From: Susan Leeson <[REDACTED]
Sent: 23 October 2024 12:43
To: Simon Davis
Subject: RE: BN/128/24/RES Eastmere
Attachments: P04 Site Plan.pdf; Site Plan (Black and White).pdf

From: Simon Davis <Simon.Davis@arun.gov.uk>
Sent: 18 October 2024 15:42
To: Susan Leeson [REDACTED]
Subject: BN/128/24/RES Eastmere

I have been looking at your application today and have identified the following matters which need further consideration from your side/amendments:

Ground Floor

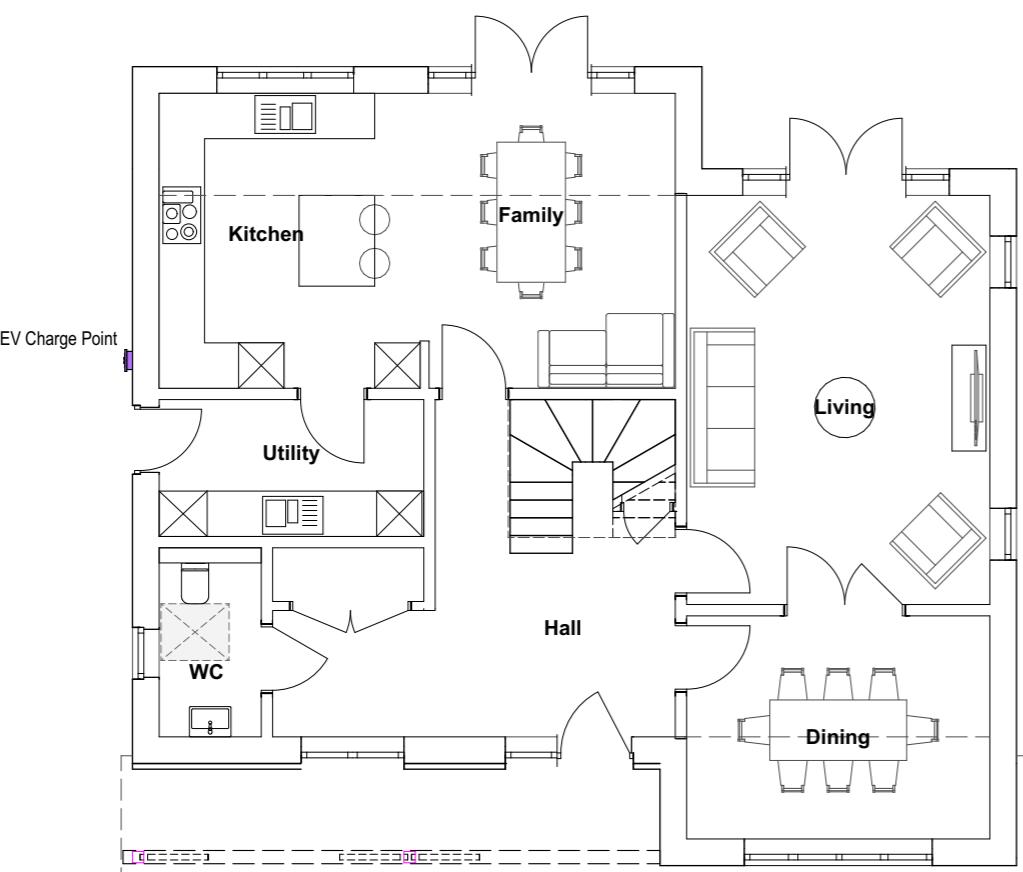
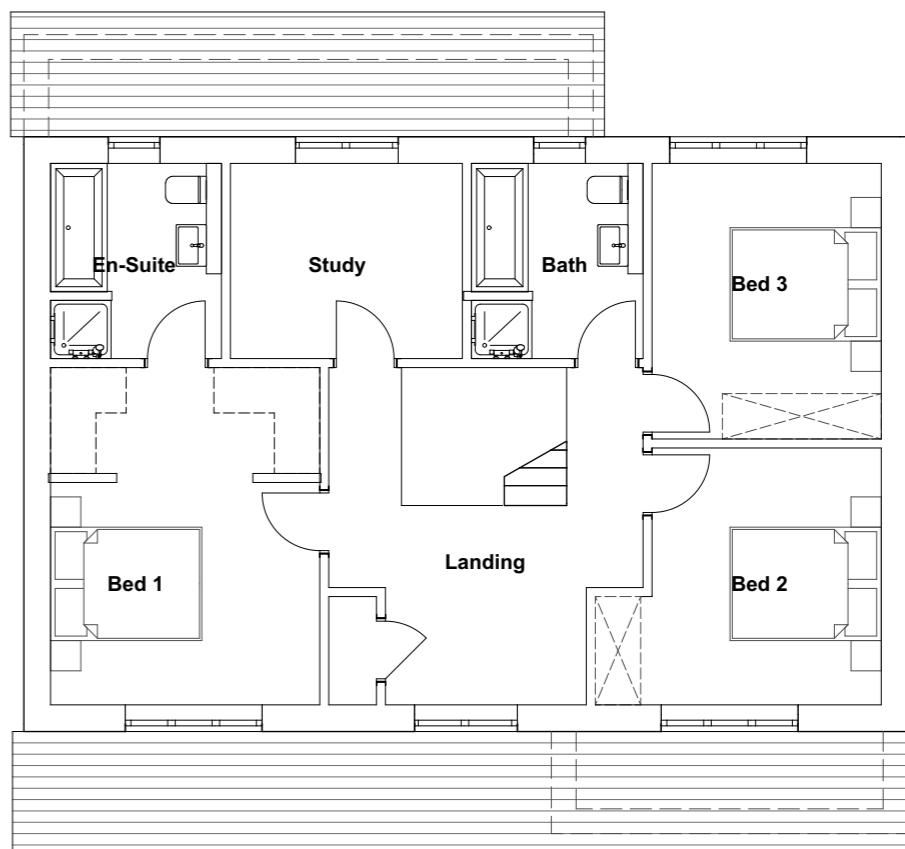
- (7) I have a slight concern with the relationship of plot 9's rear FF windows to the rear garden of plot 8 in that the interface distance is at most 8.9m when it should be 10.5m. I have no issue with the depth from a garden space perspective as it's a wide garden. I note the windows serve a study and a bathroom therefore we will impose an obscure glazing condition (O/G to a height of 1.7m above floor level, top vent opening only). Perhaps you can confirm you would accept such a condition.

Please find attached revised plan to address the overlooking issue between plots 8/9. In addition to moving the dwellings, an additional tree is introduced between these plots. Hopefully this addresses points 3 and 7.
